Submission Form

Epping to Thornleigh Third Track Proposal. Application number SSI 5132.

Name(s): Lucinda de Vries
Address: 16 Sutherland Rd Cheltenham NSW

Figure 5.6 Cross-section and elevation - New Cheltenham Station concourse building
Note: Indicatively added to future design

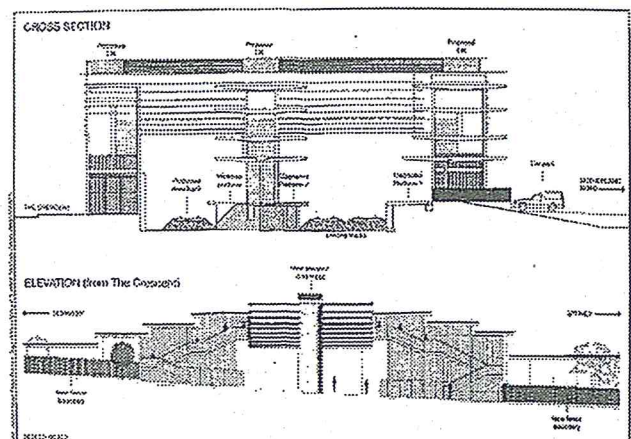
- The proposed redevelopment of Cheltenham Station shows no regard for the HCA. The visual impact of the proposed 13m high glass and steel concourse is totally unacceptable in this HCA.

Concept design drawing of proposed changes to Beecroft Station (Parsons Brinckerhoff 9/3/12). Former side platform shaded in pink.

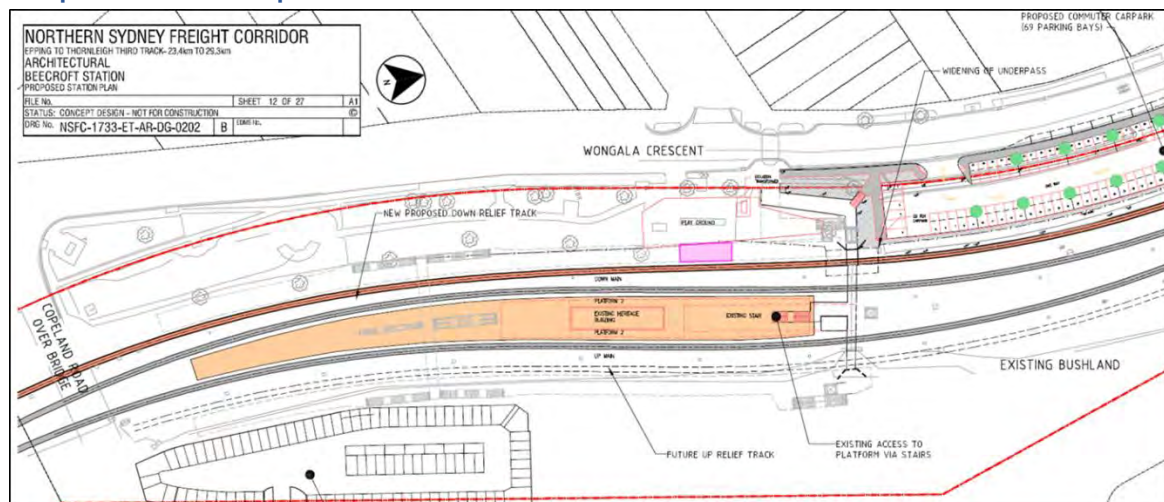
- There has been inadequate assessment of the project's impact on the fabric of the Beecroft Cheltenham Heritage Conservation Area (HCA).
- The plan given for Beecroft Railway station Precinct is vague. The relationship to the trees, playground and original 1895 platform located south of the present station is not shown. A fourth track is shown on the eastern side. The plan does not include urgently needed lifts to allow disabled access at Beecroft Station.

- Beecroft Station Gardens have a heritage listing with Hornsby Council but the impact on them has not been adequately addressed. No arborist's report is given for the trees which will be removed.
